**From:** Glenn Dahl <bmwrod1990@gmail.com>  
**Sent:** Monday, December 20, 2021 5:22 PM  
**To:** becky2@pprbd.org  
**Cc:** Kylie Bagley; Diane Joiner  
**Subject:** Fwd: Answers Regarding PCD File No. AL-21-014  
**Attachments:** Update - Site Map.pdf

This is a response to your comments on 10/28 regarding my project at 12725 Linnwood Lane, 80908.

# Planning and Community Development Department - SITE PLAN

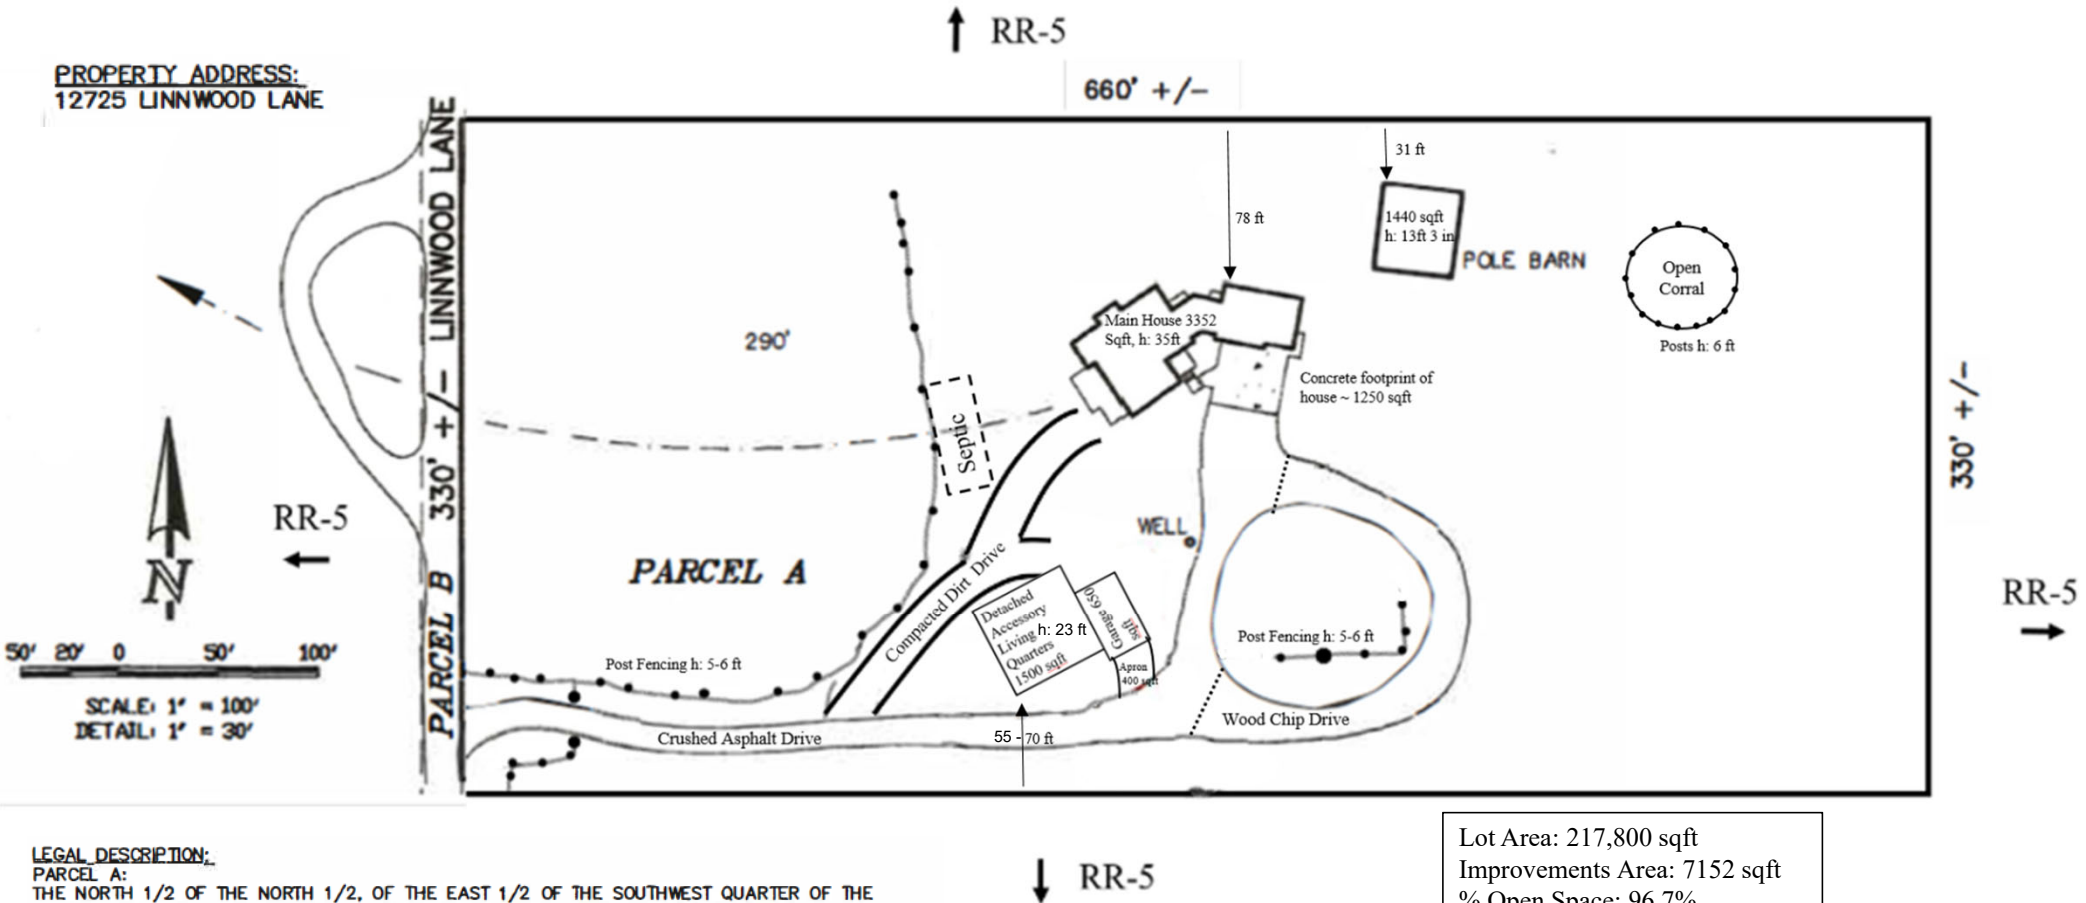
Q: Please clarify the scope of this project. The site plan provided shows an addition on the home which was destroyed in the 2013 fire. Is this a detached accessory structure as was shown on the intent letter? Our records show that there is/was a mobile home with was used when the home was being built and then would be converted into a guest house.

A: This is in fact going to be a detached accessory living quarters (DALQ) for permanent occupancy by immediate family members as stated in the letter of intent. The home burned in the 2013 fire only has a foundation remaining. This foundation is going to be removed and the DALQ will be put in its place. I have attached an updated site map that should more clearly depict the intentions for the DALQ. I apologize that the initial site map was confusing. The mobile home used during construction of the main residence was removed prior to the sale of the home and transfer to our names, so it is no longer there.
